CITY OF ALBUQUERQUE

March 27, 2019

**RE: Presbyterian San Pedro FSED
6400 Paseo Del Norte NE
Temporary C.O. - Accepted
Engineer's Certification Dated 03/26/19
Engineer's Stamp Date: 07/31/18
Hydrology File: D18D056**

SITE GRADING PLAN

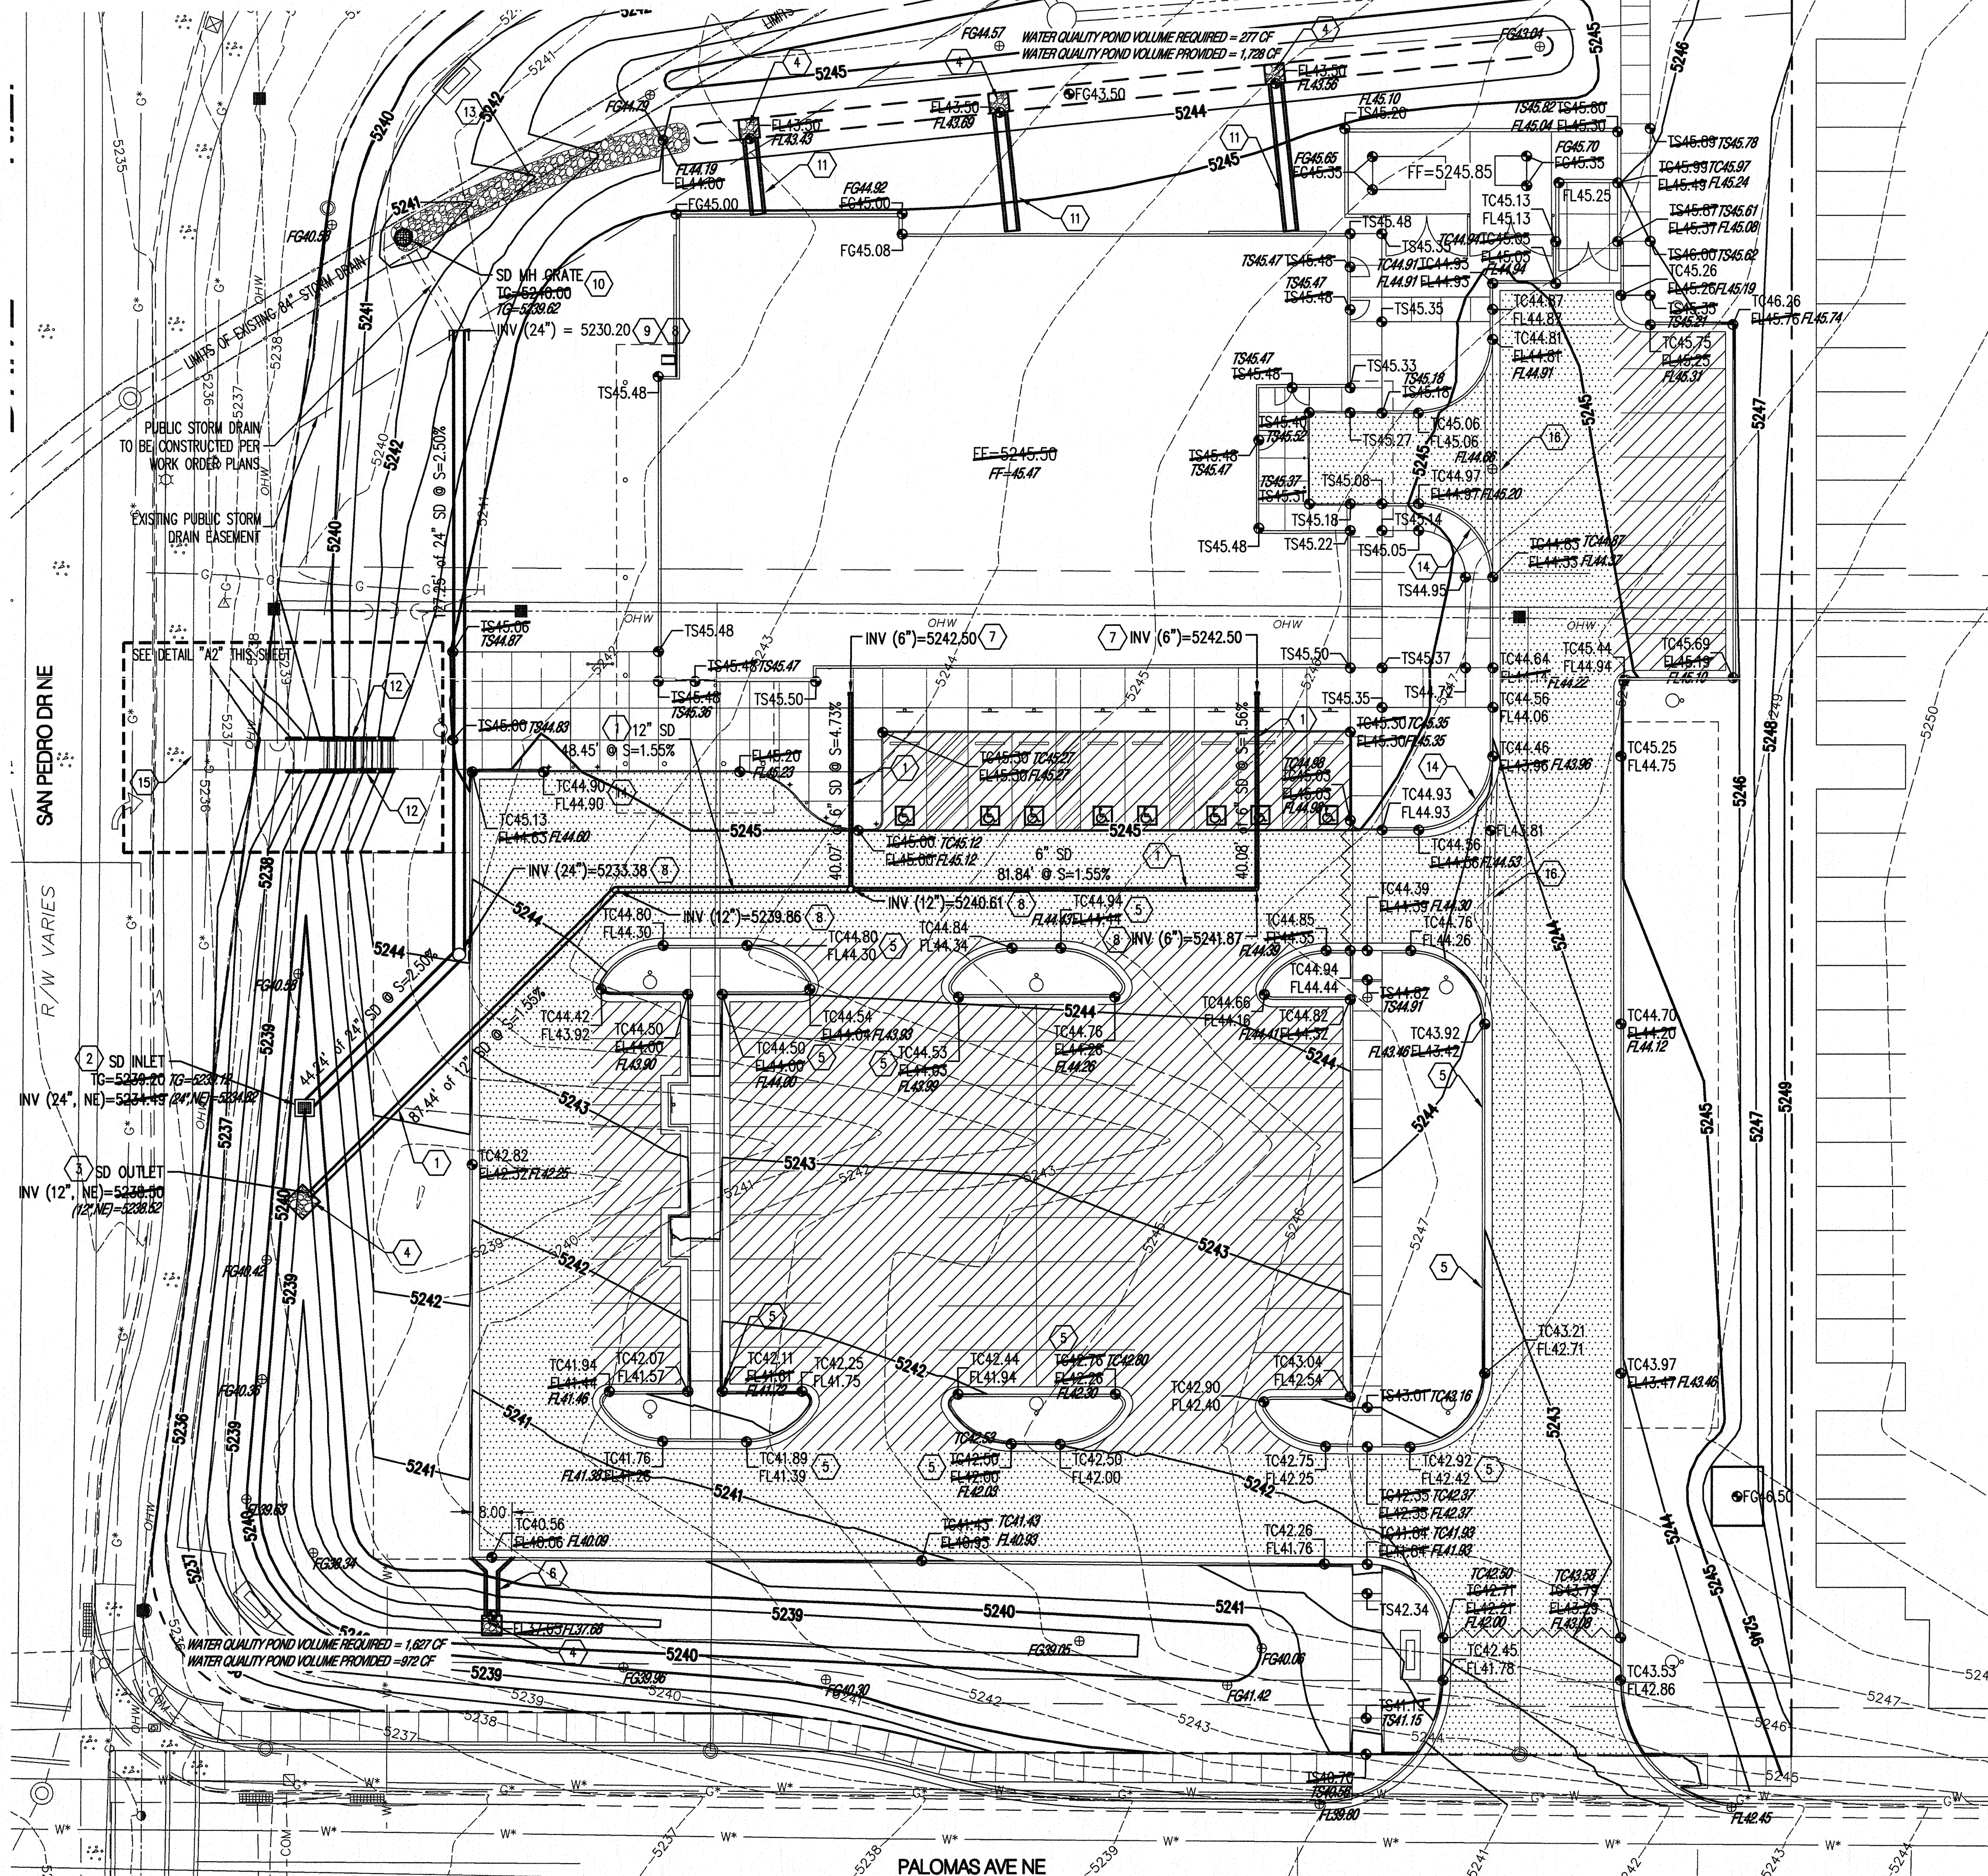
1. As indicated on the certification drawing, the North pond has a stormwater quality volume deficit of 252 CF and the South pond has a deficit of 493 CF for a total deficit of 745 CF. This can be addressed by doing either of these two options:
 - a. Widen and/or deepen one or both ponds so that the overall volume provided matches the required volume.
 - b. Do a Payment-in-Lieu for the deficit amount of 745 cubic feet. The Payment-in-Lieu payment (Amount = 745 CF x \$8/CF = \$5,960.00) must be made using a City of Albuquerque Treasury Deposit form. (if this option is picked, then I will forward the form to use. The Owner needs to bring three copies to the cashier on the Building Permits side of the ground floor and pay the fee. Once this is done, please provide Hydrology with one of the copies showing the receipt.
